Your ref
Our ref TL /3/2014/0597
Date 1st October 2014

Planning application no: 3/2014/0597.

Proposal: Outline application for up to 275 new dwellings and access. All other matters reserved.

Location: Land off Waddington Road, Clitheroe BB7 2DE.

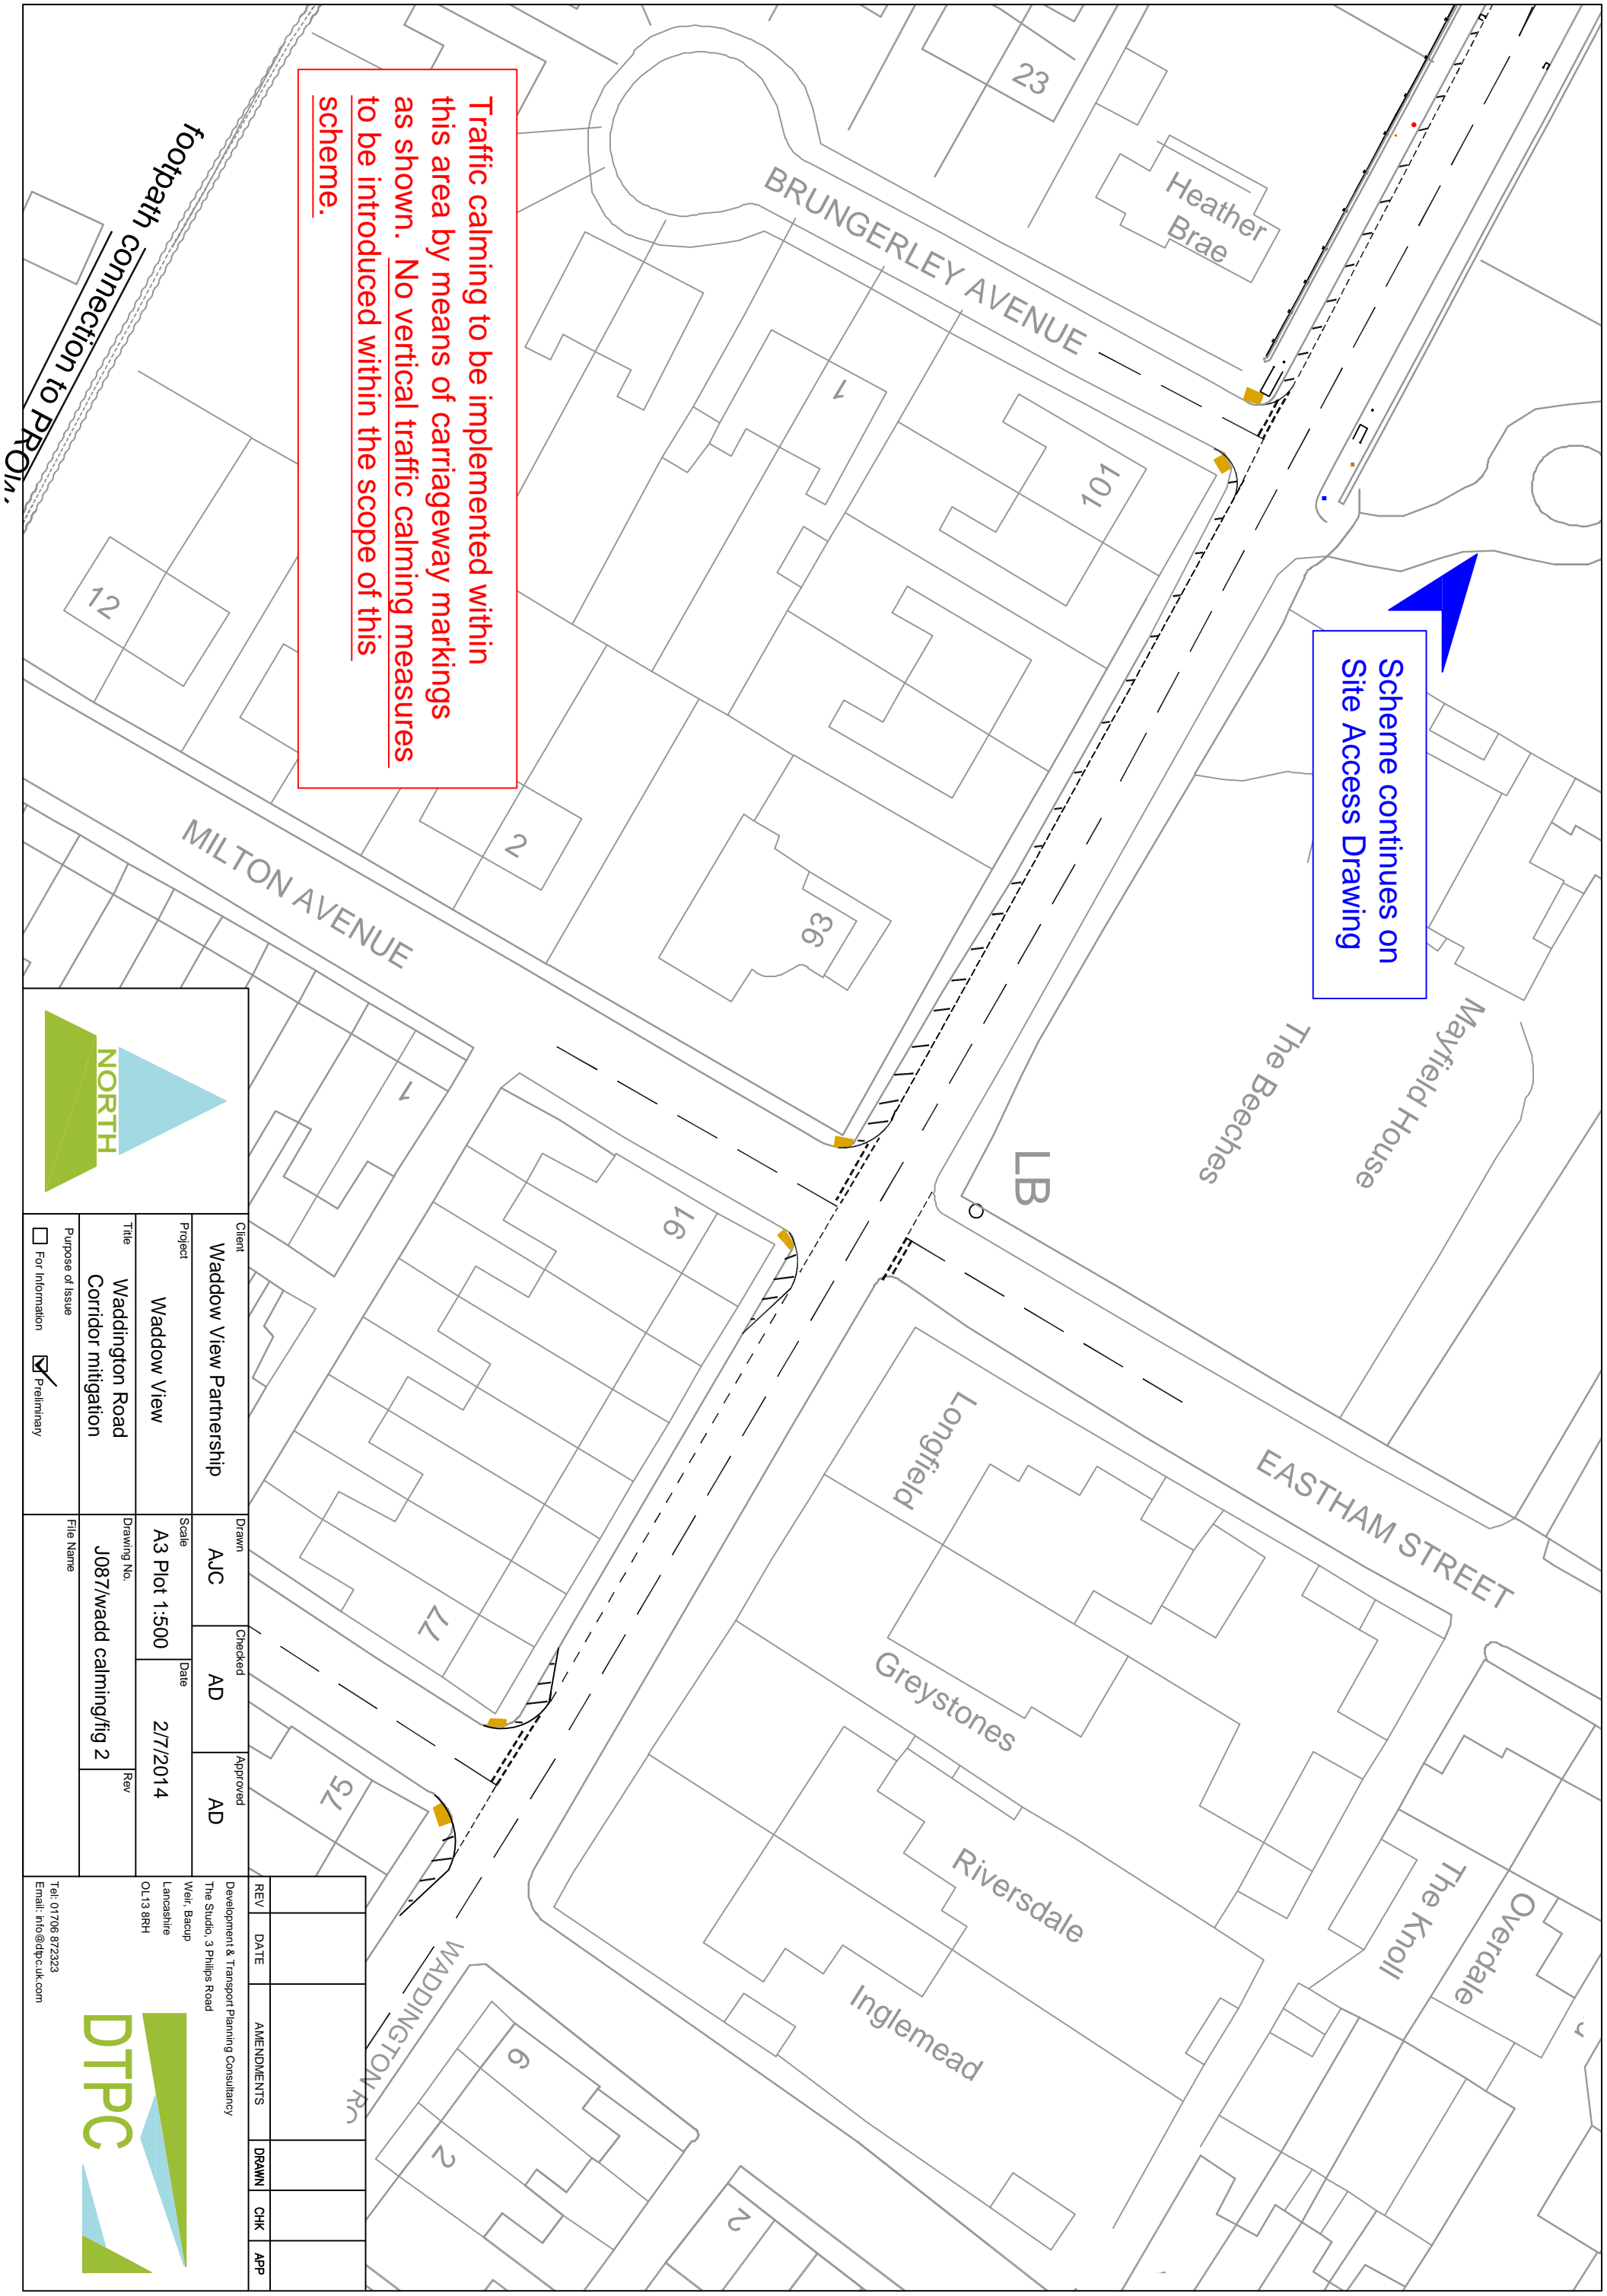
36. Waddington Road. The traffic calming, lining and minor road junction improvements are accepted in principle as shown on drawing number J087/wadd calming/fig2, although these proposals will be subject to a design review. The 20mph speed limit is to be extended past the proposed access into the development for a distance of approximately 50m north of the cemetery access. These improvements are to be paid for by the developer and implemented through a S106 agreement and a S278 agreement as appropriate. Maintenance and improvement works have been carried out by LCC on the highway drainage under the railway bridge, to mitigate the risk of flooding here and reduce the incidence of flooding severe enough to close the road.
